**APPLICANT'S COMMENTS ON THE OTHER
PARTIES EXQ2 RESPONSES**

PINS project reference: WS010005

PINS document reference: 15.3

Report Reference: AU/KCW/LZH/1724/01/15.3

Figure ESA5.1 Scale: 1:2,500@A2

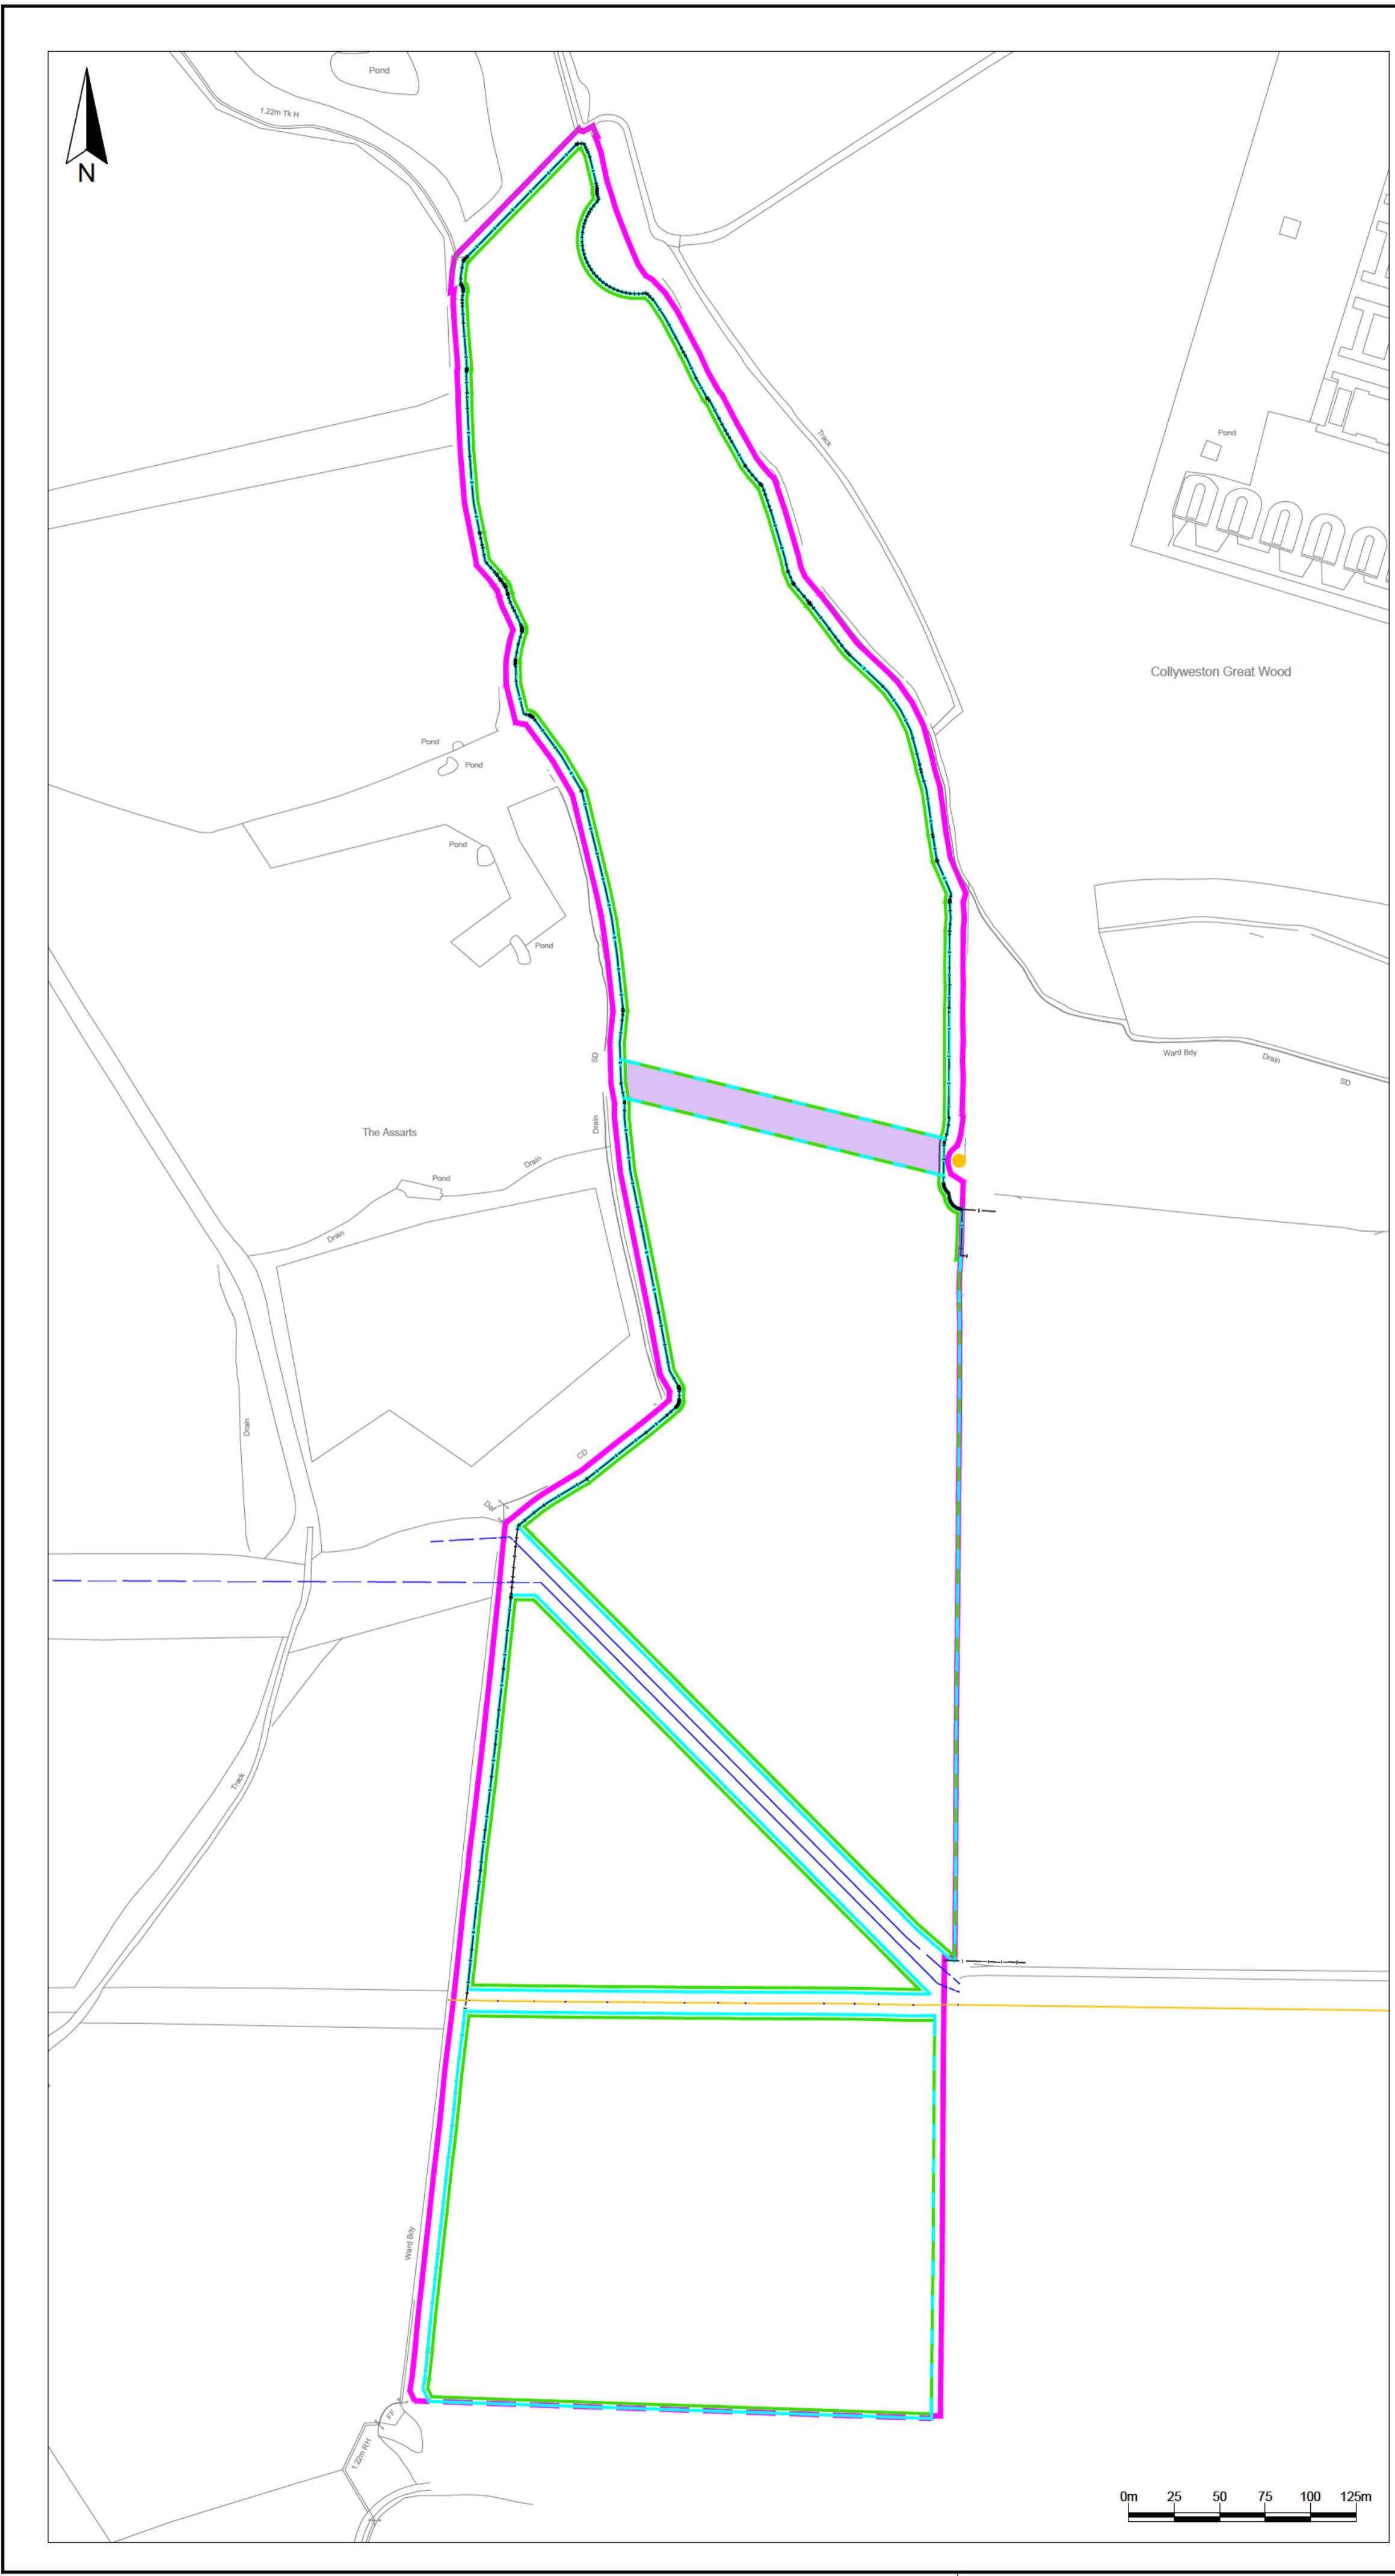
Comments from AG to Examiners questions 2	Response from the Applicant
<p>Q8.4 Please expand on the concerns set out in your D4 submissions [REP4-013 and REP4-014] with particular regard to: a) quantification of the increased risk of failure of an AW pipeline as a result of the Proposed Development;</p>	
<p>6. Our networks are assessed in accordance with our risk model, the Monte Carlo technique, which is an established mechanism. This is an industry accepted standard which takes account for age, pressure, population served and ground conditions which gives us a risk factor (or likelihood of) failure within a given time period.</p>	<p>6 & 7. The Applicant notes that the results of the analysis presented on the plan provided with the Statement and show that for a main of this type there is a low risk of failure.</p>
<p>7. Using the Monte Carlo technique I have carried out a network analysis around the Mains. A copy of this analysis can be found at pages 1. The analysis, and therefore theoretical position, for a main of this type would suggest that it is low risk. However, the model would have assumed that the Mains are undisturbed and loaded as by occasional agricultural equipment. It does not account for the fact there are two mains there, so the risk is at least doubled (as is the level of potential damage) as well as, crucially, the unique and so far undetermined consequences of Augean’s Proposed Development.</p>	<p>6 & 7. The results of the analysis presented on the plan provided show that for a main of this type there is a low risk of failure. The risks specifically relating to the development have been assessed and the results are presented in the pipeline engineering assessment report [14.6.2.3] and the Pipeline Risk Assessment report [14.6.2.2] submitted with the non material change request on 16 June 2022.</p>

<p>8. As previously noted there has already been a leak recorded in the proceeding section of one of the mains. I understand that this leak was caused by local corrosion to that section which in turn may suggest more aggressive ground conditions in this area than our risk model currently accounts for.</p>	<p>6 & 7. No detail of the incident or of the model are provided to be able to comment directly on this point. The greatest potential type of failure, if there is any failure at all, would be a leak. If a leak is undetected and unresolved, there is the potential, albeit very low, that the weakness in the pipe could increase and that a catastrophic failure could occur. It is understood that due to the method of operation of the pipeline, in which the flow is not pumped but is driven by gravity feed from the Wing Water Treatment Works, any loss in pressure resulting from a leak is compensated for by increased gravity flow therefore a leak would not be necessarily detected by a loss of pressure in the pipeline.</p>

<p>9. Previous studies have concluded that the ground conditions to this region have clays which are prone to both shrinkage and heave (I refer to the <u>Report: The Impact of Environmental Factors on Leakage in the Anglian Water Region</u> in my previous statement). Once excavation loading is removed from adjacent areas which, given the lack of detail in the phasing and excavation local to the corridor, could result in</p>	<p>8. While the probability of a leak is considered low, as explained in the Pipeline Risk Assessment report submitted on 16 June 2022 the risk of significant leaks can be reduced further by the maintenance of the existing cathodic protection and by monitoring for leaks as</p>

Comments from AG to Examiners questions 2	Response from the Applicant
<p>increasing the easement would allow safer access and vehicular movement, adequate construction zones to facilitate safe access and the ability to move materials and labour safely past construction activity in what is a corridor.</p> <p>13. Diversion of the Mains would avoid the risk of settlement of either the Mains or surrounding embankment in both construction and trafficking activities. Moving the Mains to the periphery of Augean's land would allow the Mains to be re-designed to cope with the potential for any subsequent movement during the lifespan of the Proposed Facility. Further our issues concerning sustained traffic movement and excavation to both sides would also be alleviated and reduced. Moreover not having the Mains in their current location would simplify the phase arrangement and avoid a costly bridging process.</p> <p>14. In conclusion, it is exceptionally difficult to quantify the risk posed by the Proposed Development because I do not believe Augean have considered the full long-term implications of the Proposed Development to our Mains. Due to this omission, my advice must remain that the Mains be diverted (as it was moved previously).</p>	<p>Risk Assessment report presented on 16 June 2022 [14.6.2.2] which demonstrate that in the highly unlikely event that if all the water from two failed pipes entered the adjacent landfill void, there would be no significant unacceptable environmental consequences.</p> <p>12. As demonstrated by the calculations presented in the Pipeline Risk Assessment report [14.6.2.2] the pipe corridor will not form a flooded canal that restricts access and compromises stability and integrity. The ends of the proposed pipe route are open and there is no restriction to flow. The current falls of the ground levels are generally along the line of the pipeline and fall to the north west for the majority of the pipeline route, with the south eastern third falling to the south east. Water is therefore unlikely to pond in the area of the pipelines. In addition, ditches can be installed at the edges of the corridor to provide confidence regarding effective drainage if there remains any justified concern.</p> <p>13. Anglian Water maintain that it is their preference to divert the pipelines around the landfill outer boundary. It is demonstrated in the Pipeline Risk Assessment presented with the application for the non-material change submitted on 16 June 2022 [14.6.2.2] that the development can proceed without resulting in any significant adverse effect on the pipelines including on the ability of Anglian Water to obtain access to repair the pipelines. Accordingly there is no need for the pipelines to be diverted.</p> <p>14. If the pipelines were to be diverted to follow the eastern, southern and western boundaries of the proposed western extension a much longer pipeline route would be required (approximately 1,000m compared with the current route of approximately 350m). This longer route would still be adjacent to the boundaries of landfill phases for the entire length therefore it is unclear what benefit Anglian Water perceive would be achieved. The western boundary of the proposed western extension (approximately 450m) is adjacent to The Assarts</p>

Comments from AG to Examiners questions 2	Response from the Applicant
	<p>woodland and, as established through the ecological surveys and assessments presented in the application documents, the grassland along the woodland boundary is of significant ecological value. A wide strip of land (suggested as 40m by Anglian Water) would need to be established without tree cover and the pipes would need to be placed into a new trench excavated along this boundary. The diverted water pipes also would need to cross over or under the high pressure gas pipeline twice, once at the eastern side of the proposed western extension and once at the western side. The potential impacts and difficulties associated with a diverted route for the water pipes are significant and likely to be greater than the impacts associated with leaving them in place combined with an agreed appropriate stand off distance to allow for access should repairs be necessary.</p>

<p><i>b) the options for avoiding/mitigating the increased risk of failure of the pipeline (for example, routes for diverting the pipelines or, if the pipelines were retained in their current positions, increased stand-off distances and/or enhanced protective measures or changes to the design of the Proposed Development;</i></p>	
<p>15. The Mains are currently located circa 10 meters from Augean's Southern Boundary excluding any buffer zone from phases 3A, 4B, 5B, 6 and 7. Unfortunately I have no details as to the previous easement agreed for the Mains and cannot comment on the assessment for the easement width which was undertaken at that time.</p> <p>16. The current acceptable standard operated by the industry follows a general guidance (pages 2 to 9) ("the Guidance"). The Guidance provides that a pipe of this size (800mm) would require a minimum of 12 meter easement (page 6). However, this measurement assumes that access is generally unfettered and that it is a single main. In this case there are two mains and they are bounded by banked inaccessible ground (either by excavation or capped phase areas) allowing access only from the corridor ends. My understanding is that the corridor will be circa 350 meters long. In the event of a major leak the corridor itself would act to channel the escaping water into the access path. An increased width (if the Mains were to remain in their</p>	<p>15.& 16 The application for the non-material change submitted on 16 June 2022 [14.2] demonstrates that the estimates for the space needed for access to the pipelines range from 8.5m to 20m to the side of each pipe therefore 20m is the maximum that is likely to be necessary. A total easement width of 40m which is suggested as 'ideal' by Anglian Water in paragraph 17, taking into account the distance between the pipes of approximately 5m and the total width of both pipes which is 1.6m, correlates to a standoff distance of 16.7m away from each pipe $[(40-6.6)/2]$ which is well within the standoff of up to 30m from each pipe proposed in the non-material change request. It is therefore clear that the standoff now requested by Anglian Water can be accommodated in the application as now proposed including the standoff of up to 30m which is the subject of the non-material change to the application.</p> <p>17. Discussed in relation to question 13 above.</p>

Comments from AG to Examiners questions 2	Response from the Applicant
<p>current location) would allow improved access and the ability to move equipment around the rupture and crater zone in a safe manner without compromise or risk to Augean's work area.</p> <p>17. Without prejudice to my position that the Mains ought to be diverted, in terms of potential easement widths, Anglian Water is currently installing a major strategic pipeline and our learning from the Lincoln to Grantham section which is also an 800mm pipe is that our easement assessment (referred to above) is incorrect and ideally for sufficient working it should be 40 meters.</p> <p>18. I would request an extended easement width to allow access following worse case conditions, given our limited corridor and flood potential, as described above. During the construction and fill periods, provision should be allowed for bank stability monitoring, possible hydrophone installation for early leak detection. We would need to be assured that loading of vehicles crossing our lines would in no way impact on them by provision of a suitable independent bridging structure. In summary Anglian Water would need to be provided with:</p> <ul style="list-style-type: none"> a. Stability monitoring of easement bank; b. Plans of how they propose to go over the pipe (their proposal) and location; c. Proving that no external loads will be placed on the Mains; and d. Monitoring of water levels within the existing pipe trench e. Mains' bedding. <p>19. Notwithstanding my comments above in relation to easement width, I would re-emphasises that this is still not a viable solution in view.</p>	<p>In response to the items listed in paragraph 18, the Applicant provides the following response:</p> <p><i>a. Stability monitoring of easement bank;</i> As explained in the Pipeline Risk Assessment report submitted with the non-material change application [14.6.2.2], monitoring of the stability of the excavated, operational and restored landfill site is the subject of the Environmental Permit and will be carried out by Augean as required by the Environment Agency.</p> <p><i>b. Plans of how they propose to go over the pipe (their proposal) and location;</i> Based on the assessments carried out [14.6.2.3], it is concluded that a suitable crossing over the pipelines can be constructed readily, using standard methods that will protect the integrity of the pipelines. Nevertheless, the comments of Mr Frogatt are noted and a specification for design of the crossing will be discussed and agreed with Anglian Water at the appropriate time pursuant to the proposed Protective Provisions for the benefit of Anglian Water. Anglian Water have stated [REP4-014] that they do not require a separate crossing agreement.</p> <p><i>c. Proving that no external loads will be placed on the Mains;</i> It is demonstrated in the assessments carried out and presented in the report at Appendix SES2.2 [14.6.2.2] to the non-material change request that there is no risk of unacceptable adverse effect on the water pipes as a result of external loads.</p> <p>and</p> <p><i>d. Monitoring of water levels within the existing pipe trench mains' bedding.</i> The Applicant has offered to install facilities in order to carry out this monitoring. As a result of the low probability of failure and the lack of evidence based on the risk assessments presented below that the proposals could result in any increased risk of failure of the</p>

Comments from AG to Examiners questions 2	Response from the Applicant
	<p>pipelines, it is considered that any additional monitoring for leaks is not necessary as mitigation as it is not required to control environmental impacts or effects of the proposed development. The option of such monitoring is suggested by the Applicant to provide additional comfort to Anglian Water in order to reach agreement on a sensible standoff distance. Accordingly any commitment relating to monitoring which might be undertaken will be secured through the Protective Provisions with Anglian Water.</p>
<p><i>c) provisions to allow satisfactory access to maintain and repair the pipelines.</i></p>	
<p>20. The bare minimum standard, as per the attached document for this size of pipe is 12 meters (access to twin pipes cannot be across or over the other pipe). However, for reasons outlined above the corridor, especially in the finished condition some years hence when the pipe has advanced in failure risk, will channel any subsequent flows from a rupture directly to the working area and accesses. By diverting the Mains this will allow safe access to the rupture and working zone for further support plant and personnel as required.</p> <p>21. Previously there has been indication that a high voltage cable would be installed near the Mains. If this were to occur we would not be able to safely place mechanical excavation within 3 meters of this, further widening the easement request.</p> <p>22. In terms of an absolute minimum easement width, a theoretical calculation may assume; a 20-tonne tracked excavator allowing 4 meters track extending to 6 meters for slewing, 1 meter minimum for edge of passage, haulage road 6 meter plus a minimum segregated pedestrian walkway of 1.5 meters. This working zone will of course be distanced from the pipeline to avoid loading, and an eruption/excavation crater of a minimum 4 meters (conservative). This would take us to a minimum from edge of pipe of circa 20 meters plus. Whilst it is tempting to assume that in emergency situations, we would compromise these arrangements as an organisation we pride</p>	<p>20 to 22. As stated above, the non-material change request submitted on 16 June 2022 [14.2] demonstrates that the estimates for the space needed for access to the pipelines range from 8.5m to 20m to the side of each pipe therefore 20m is the maximum that is likely to be specified. A total easement width of 40m which is suggested as 'ideal' by Anglian Water in paragraph 17, taking into account the distance between the pipes of 5m and the width of the pipes of 1.6m, correlates to a standoff distance of 16.7m away from each pipe $[(40-6.6)/2]$ which is well within the standoff of up to 30m from each pipe proposed in the non-material change request. It is therefore clear that the standoff now requested by Anglian Water can be accommodated in the application as now proposed including the standoff of up to 30m which is the subject of the non-material change to the application.</p> <p>23. No information was provided on the pipe crossing as it was specifically excluded by Anglian as a matter for consideration at this time [REP4-014]. Based on the assessments carried out [14.6.2.3], it is concluded that a suitable crossing over the pipelines can be constructed readily, using standard methods that will protect the integrity of the pipelines. There will be no need for piling associated with the design of a suitably robust and protective crossing point. A specification for design of the crossing will be discussed and agreed</p>
